### DRB CASE TRACKING LOG

Re Project 1001985 – Lot 6, block 3, Sandia Research Park

## OFFICIAL NOTIFICATION OF DECISION

FILE: **Project 1001985**  
02EPC-00829 SDP -- Building Permit

Site Plan

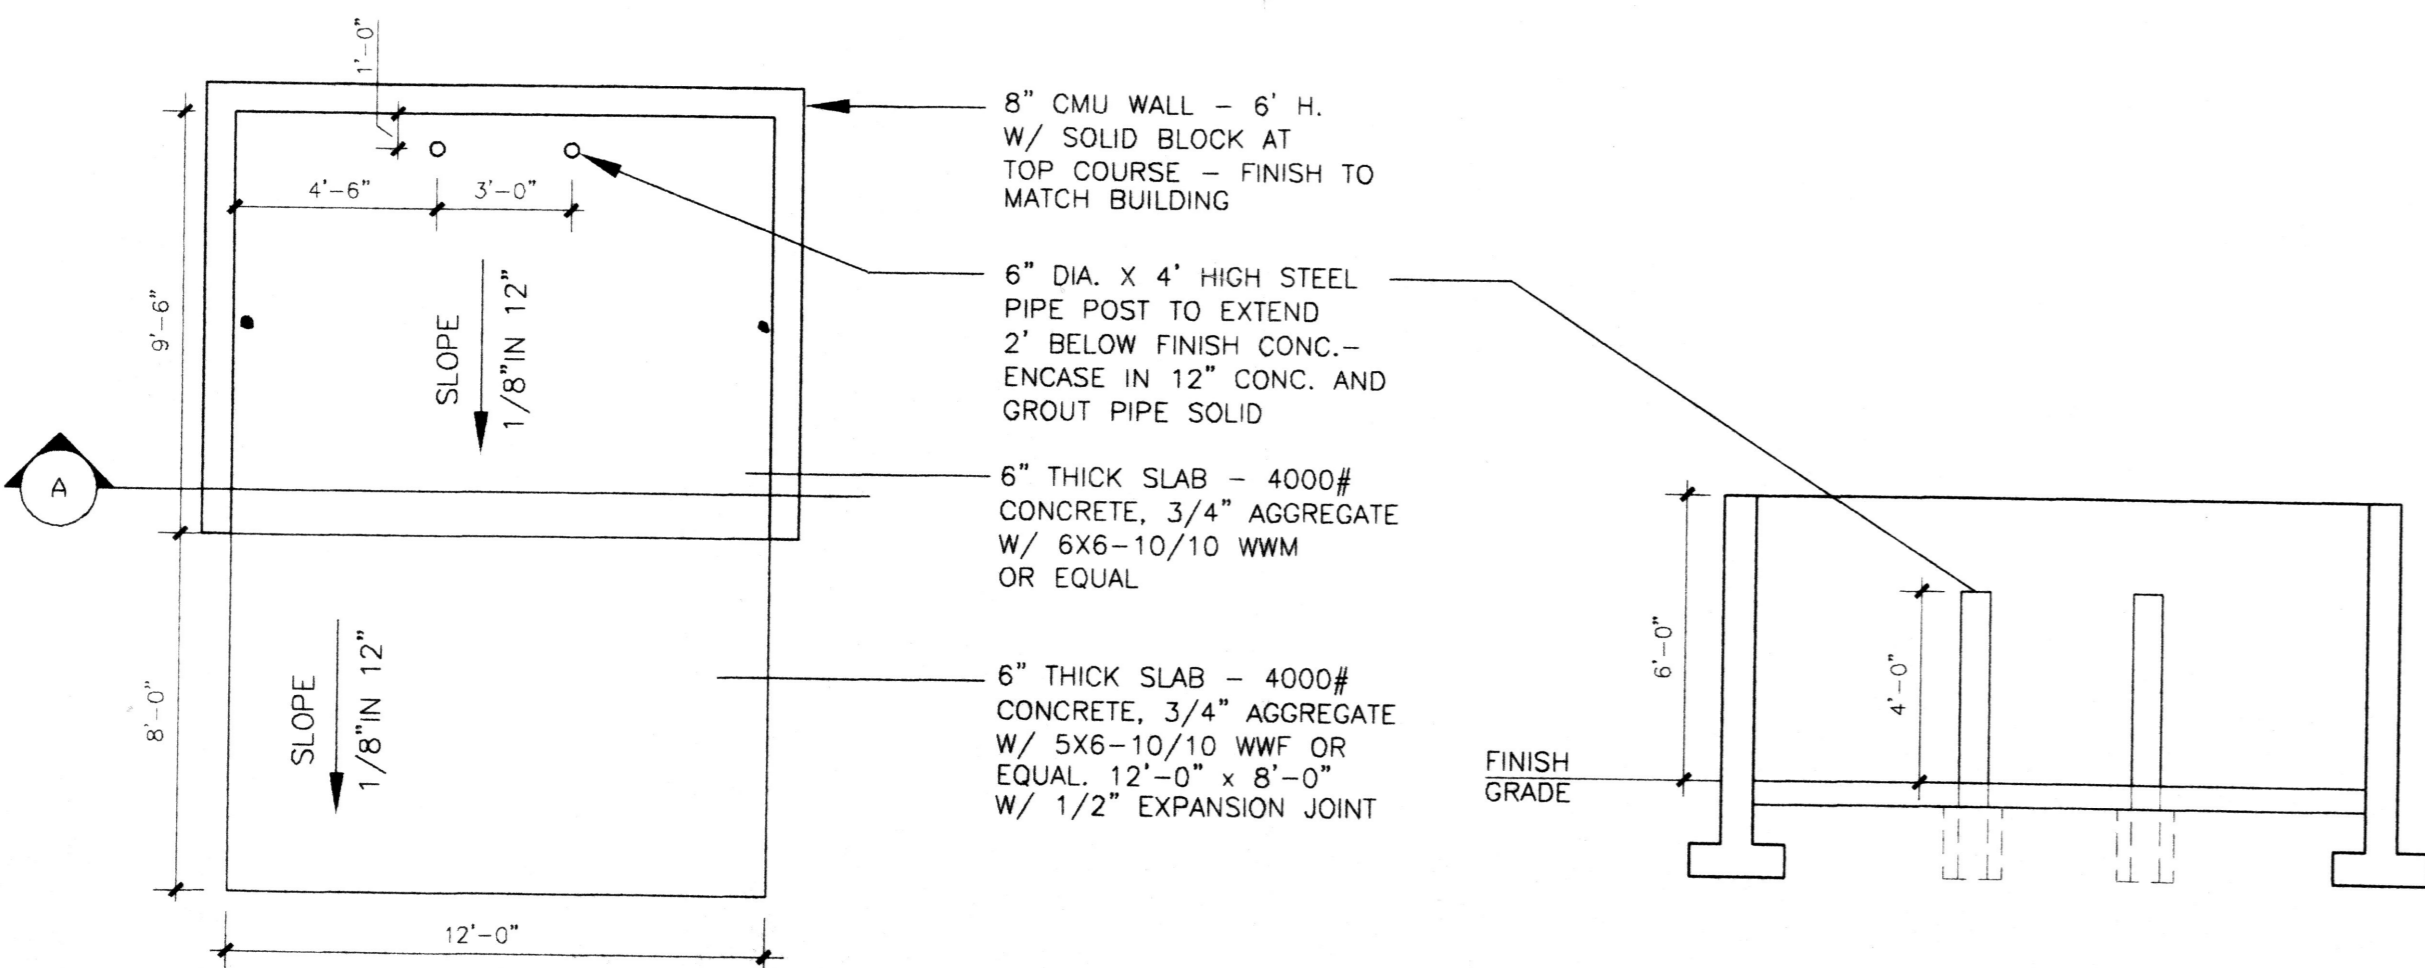
2. Pedestrian crossings that are a minimum width of 6-feet wide which are clearly demarcated with slightly raised and/or textured paving shall be provided where pedestrian paths cross vehicular entrances and drive aisles.

- c. Use drivepad instead of curb returns for east driveway on Research Rd. This will contain the driveway within the boundaries of the site.
- d. Position site drives on Research Rd., across from existing site drives on south side, per DPM standards (show on site plan).
- e. Provide cross access agreement between this lot and lot 5 to the north.
- f. Provide temporary connection/turn-around, to lot 5, at end of drive aisle on east side of building.
- g. An approved conceptual grading and drainage plan is required for Site Plan sign-off by the City Engineer & AMAFCA. Approval of drainage plan required prior to placement on DRB agenda.

- 2 The pedestrian crossing has been revised – see key note 1, sheet 1.
- 3 The sign elevation has been revised to more clearly show compliance – see sign elevation on sheet 2.

- 10c The east driveway was changed to curb returns as requested.
- 10d The drive aisle was relocated as requested.
- 10e Cross access to lot 5 is noted
- 10f Refuse truck maneuvering was discussed with Teresa Baca, she concurred that baking up will be acceptable until lot 5 develops.

North Elevation

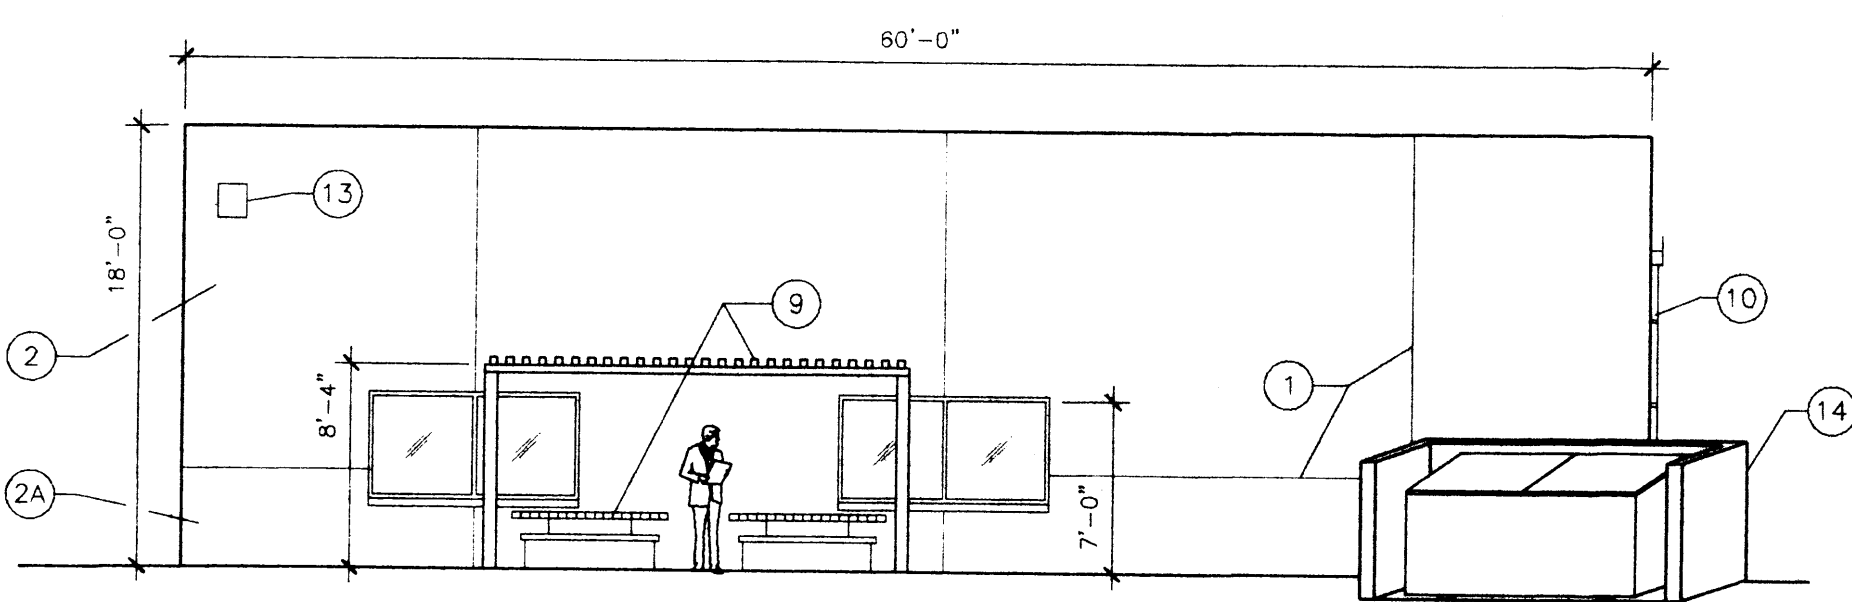
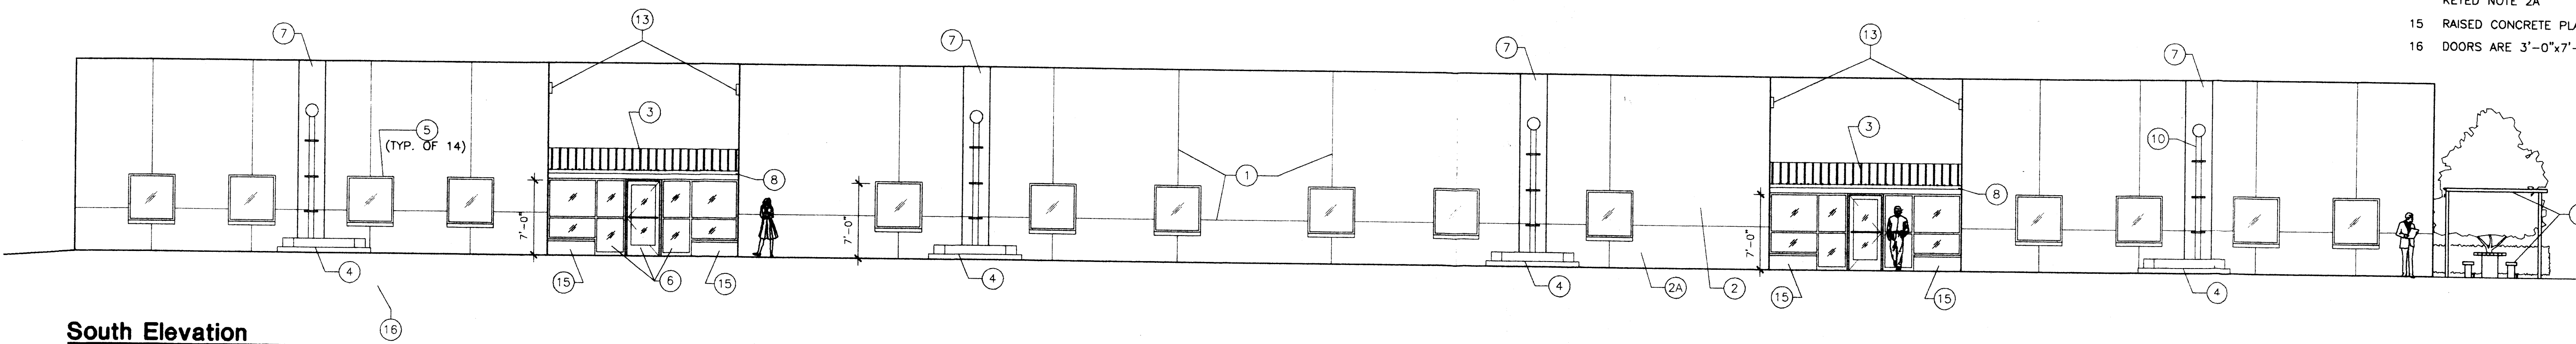
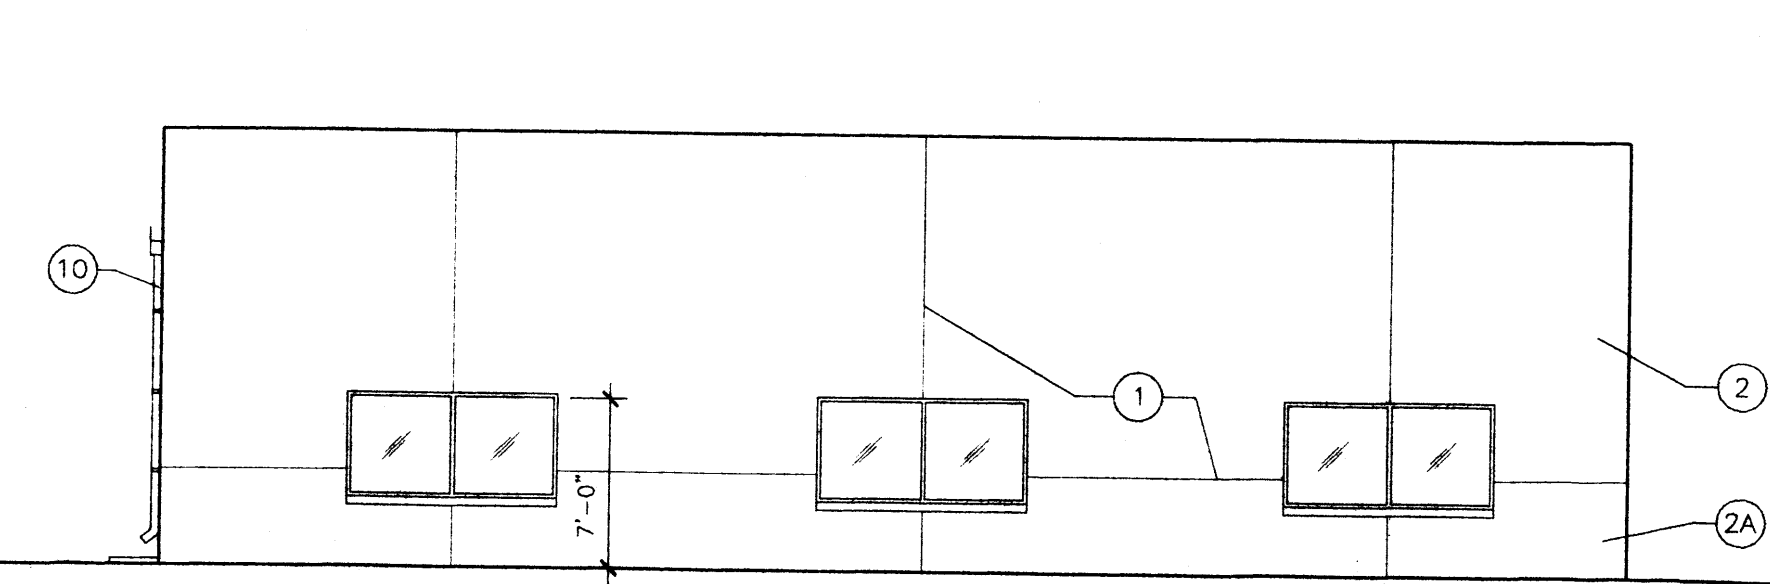
8. All colors and materials shall be listed on the elevation sheet prior to final sign-off at the DRB.
9. Traffic Engineering shall approve the alignments of the proposed driveways with the adjacent properties.

- 6a, 6b, 6c, 6d – All directives have been met, see sheet 3.
- 7 Screen shall be accomplished by use of evergreen shrubs – see sheet 3.
- 8 Colors and materials are noted on sheet 2.

B Elevation At Monument Sign

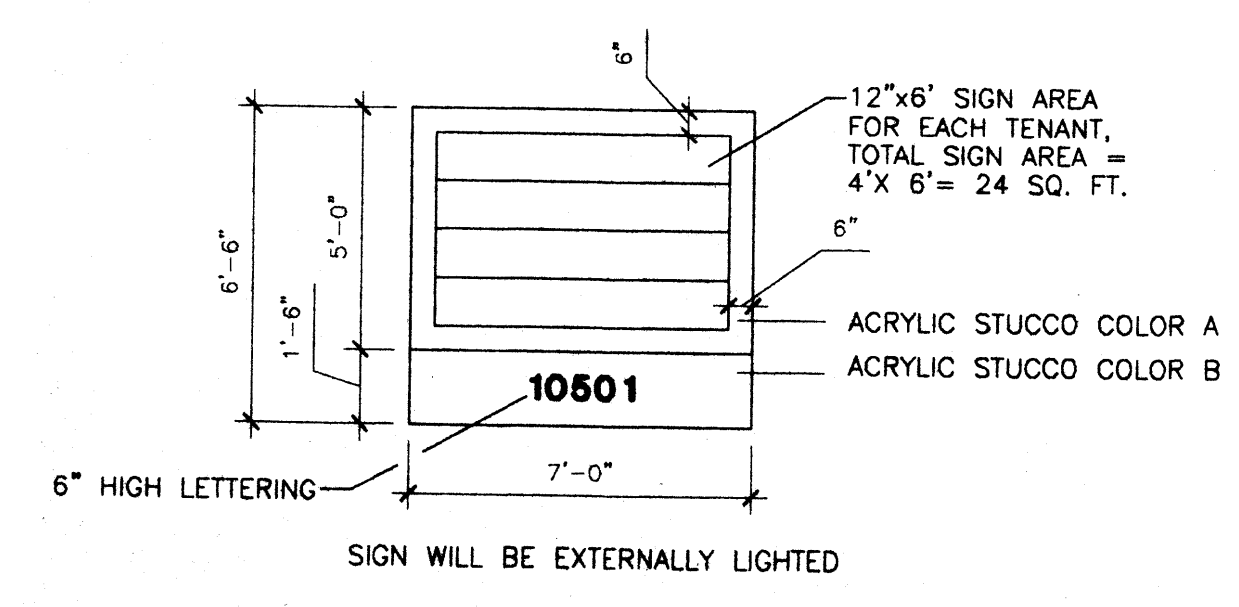
3. The site shall contain one monument-style sign per street frontage and the sign shall not exceed 50 square feet in area and 6-feet in height.
4. No chain-link, razor wire (concertina) or plastic vinyl fencing is permitted.

Landscape Plan

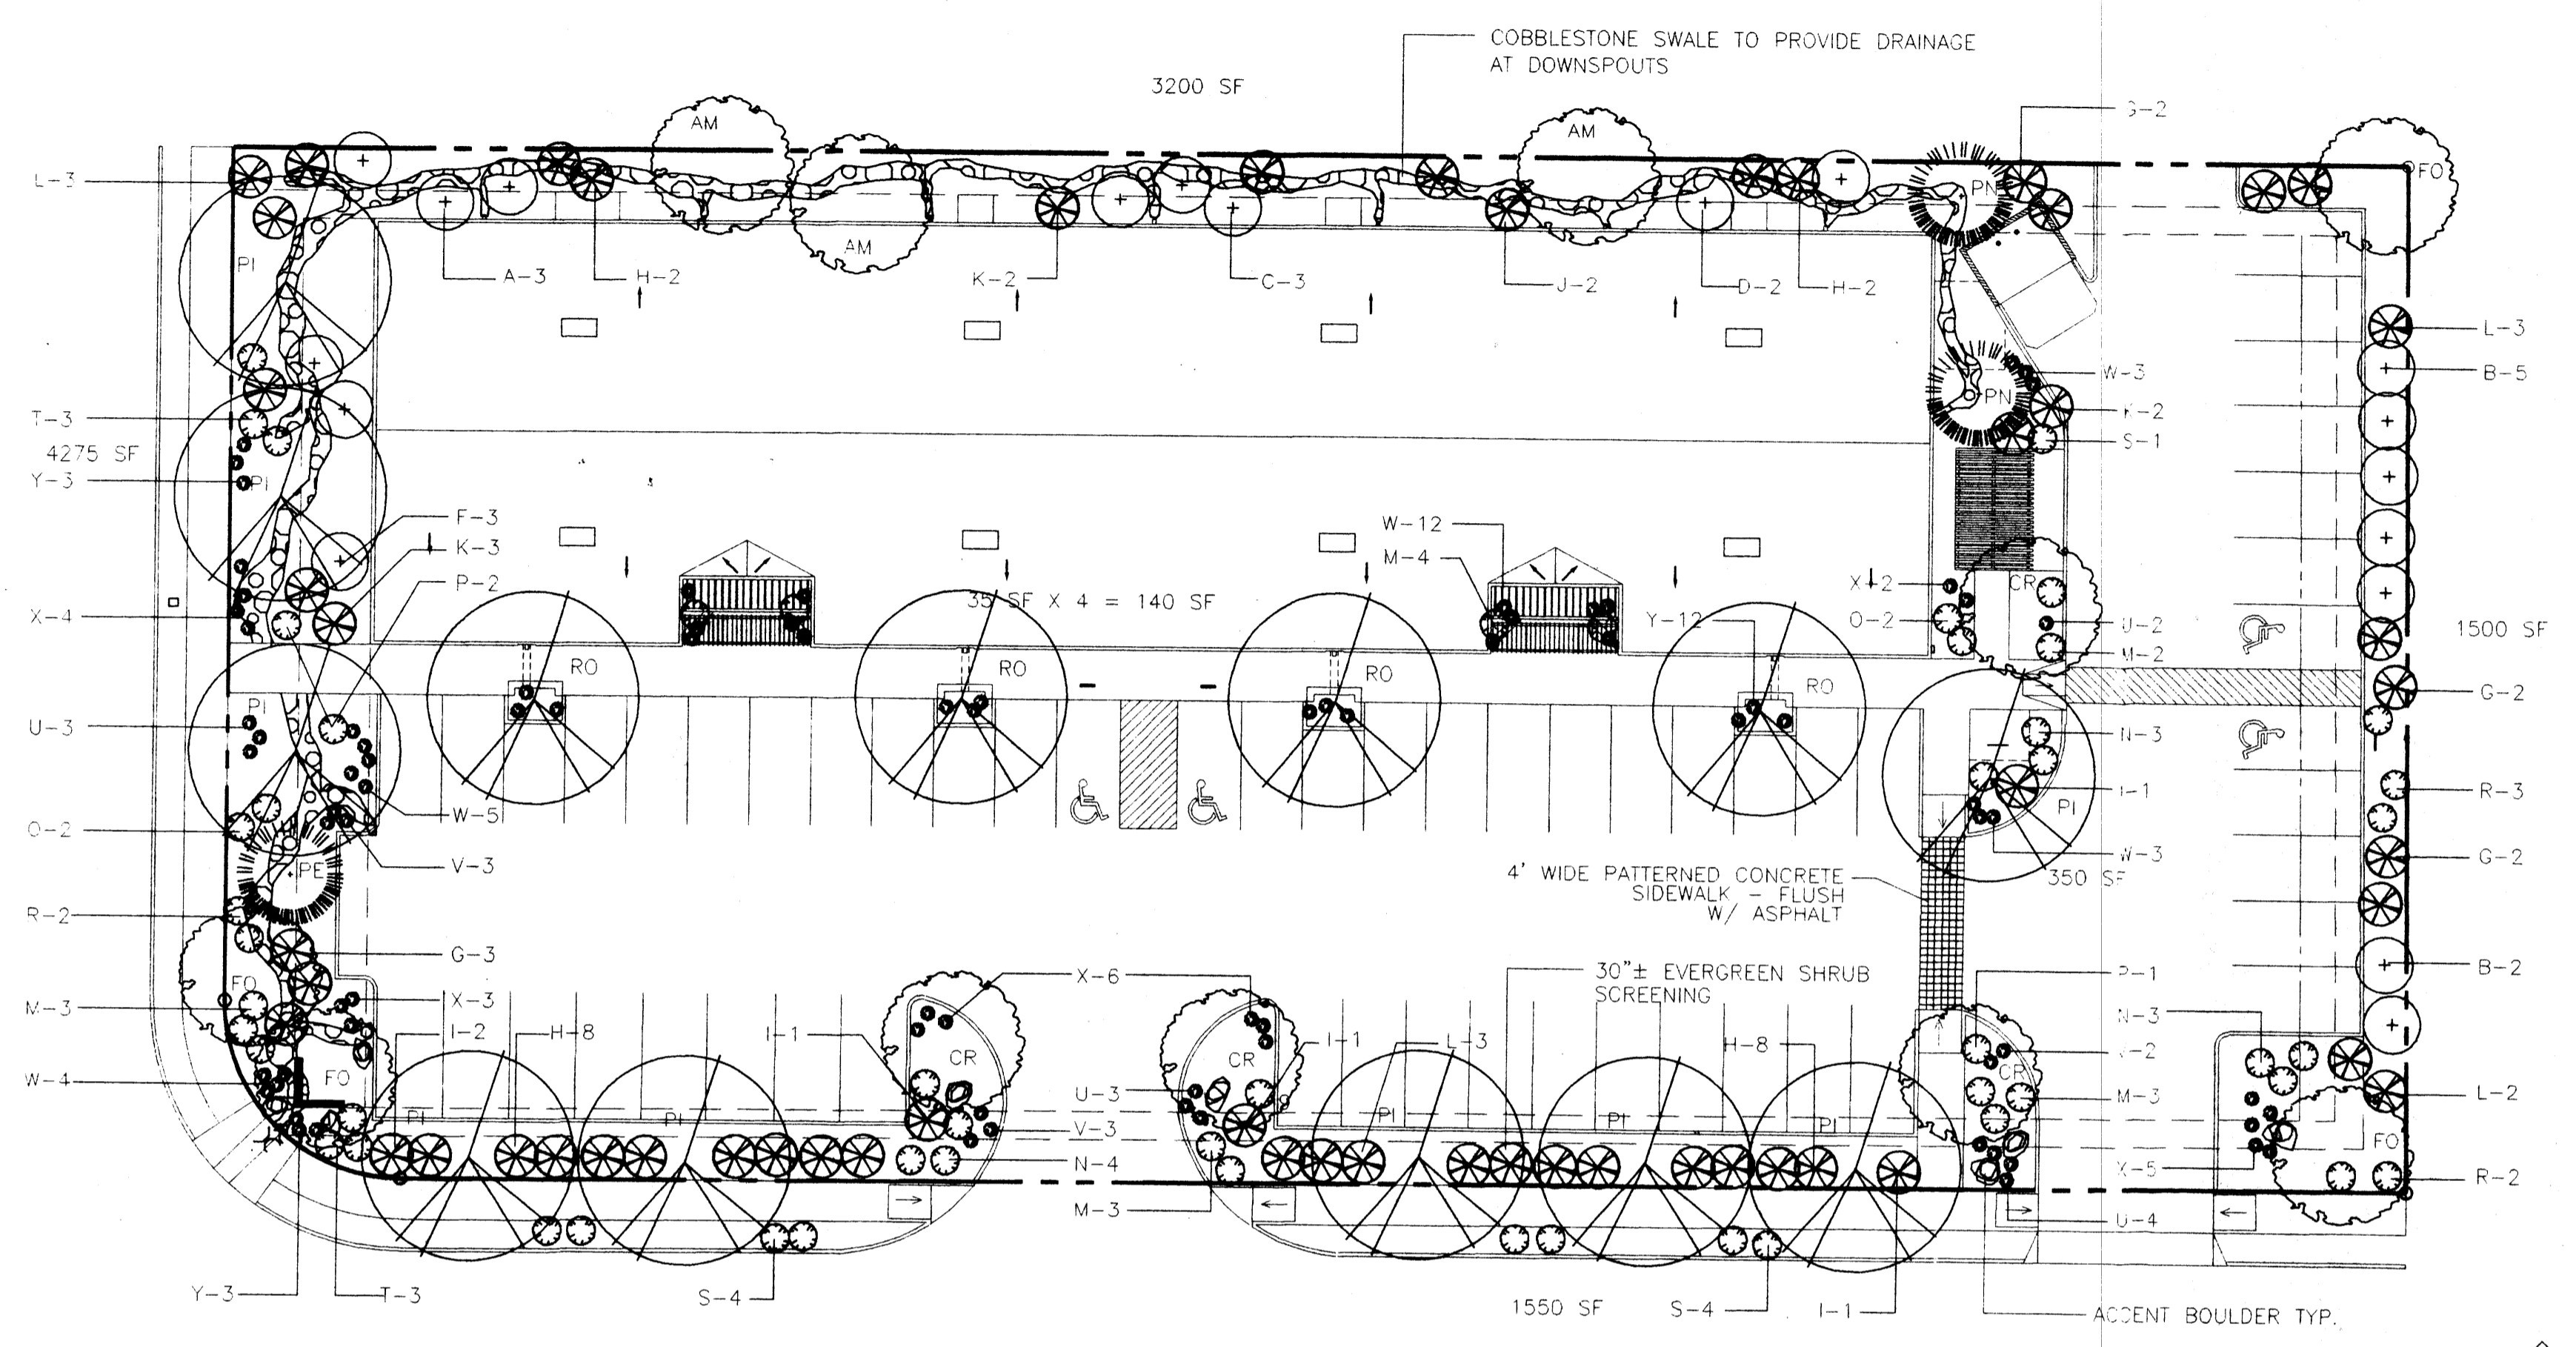
5. No freestanding cell towers or antenna shall be permitted. Any such antenna shall be integrated into the building architecture.
6. Landscape Plan:
  - a. The statement regarding the intent to comply with the City's water conservation and wastewater ordinance shall be re-worded to say, "Approval of the landscape plan does not constitute exemption from the C.O.A. Landscape and Water Waste Ordinance".

- b. All evergreen trees shall be a minimum 8-feet in height at time of planting.
  - c. The Pistache tree shown at the southeast corner of the site is under a PNM easement and shall be substituted for a shorter species such as the New Mexico olive.

- d. Each species shall be identified with an individual symbol.
7. Low walls or landscaped berms 2 ½ to 3 feet high or hardy shrubbery that is thick and will reach maturity rapidly shall be used to screen parking areas from the street. Walls shall integrate with building architecture/colors.
